Applicant: Oxford University Development Ltd

Proposal: Discharge of Conditions 18 (turning area specification) and 20
(Construction Traffic Management Plan) of 18/00803/OUT

DATE: 18 July 2022

Type F2 - Footway construction - plane and overlay
 Surface Course: 20mm, AC6 dense surf, 100/150, PSV 45, to BS EN 13108-1
 Regulating Course: (where required) AC 20 dense bit, 40/60, Specification Clause 929

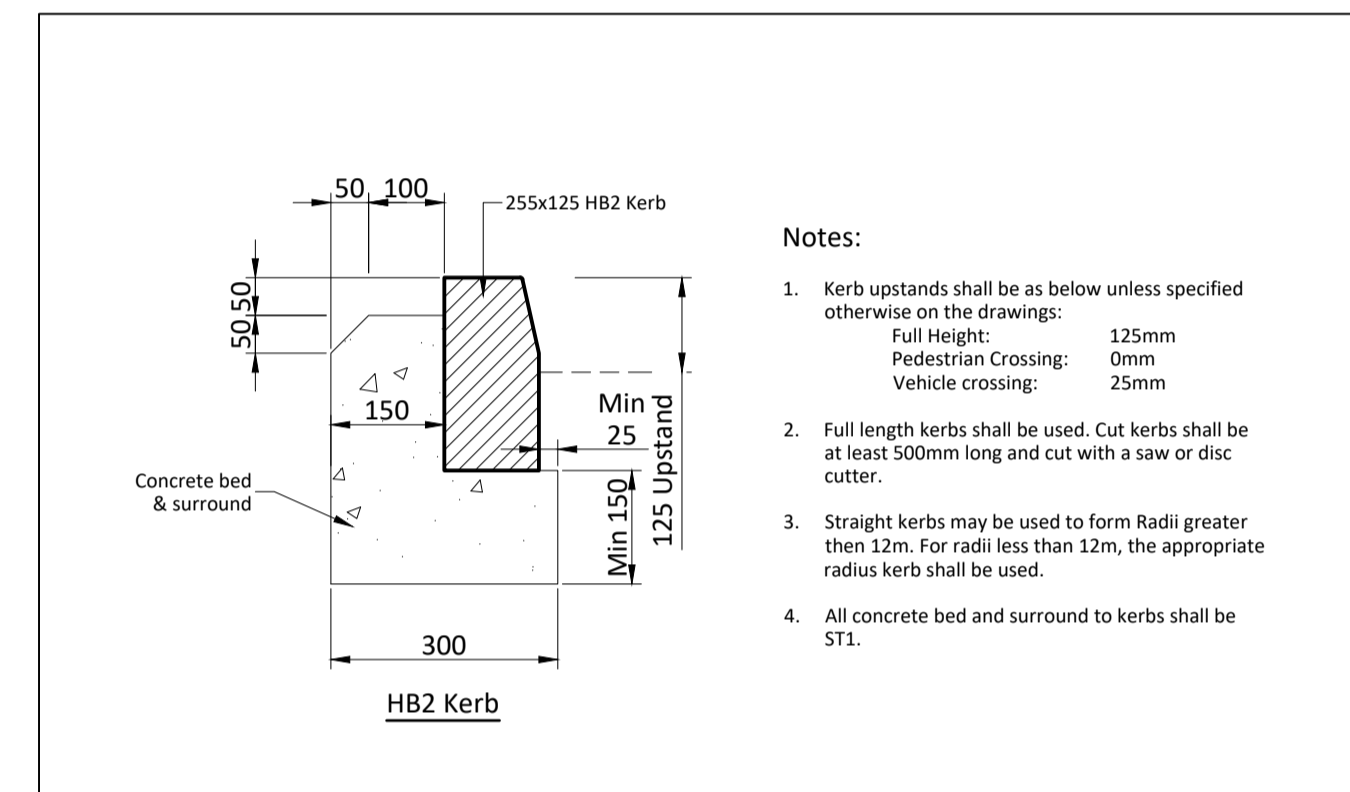
- 4.1 **OCC – Transport** – Initial objection to the discharge of conditions 18 and 20. Not all vehicle spaces within the site including those that are situated within the car park have the required 6.0m manoeuvrability and the number of spaces pictured within Appendix 1 does not match those detailed within the technical statement. The names of the project supervisor and site manager were disclosed, but no contact details provided and the secondary access via Sandy Lane states within the plan

6.1. Condition 18 – This condition relates to parking provision and manoeuvring within the site. The submitted drawings and documentation were assessed by OCC as highway authority who raised an initial objection. The OCC guidance for space between vehicle parking bays measures 6.0m so that cars can swing into spaces. Many of the spaces did not comply which ultimately jeopardises the condition as it may restrict vehicles' ability to reverse and leave the car park forwards as well as general manoeuvrability and convenience. This was emphasised by the exclusion of a turning area. This will need to be amended before the condition can be discharged. The number of spaces to be provided is unclear and must be clarified.

6.2. Following a meeting with OCC, the proposals were clarified and amended accordingly, and the revised proposals are now acceptable to OCC. It is therefore agreed that this condition can be discharged accordingly, based on the revised plans.

Drawing numbers: IMA-21-071-016 Rev D; LP2264-FIR-00-ZZ-DR-L-0007 Rev 02 and as clarified by comments to OCC by agent to initial consultation response dated 30.06.2022 and Technical Note dated February 2022.
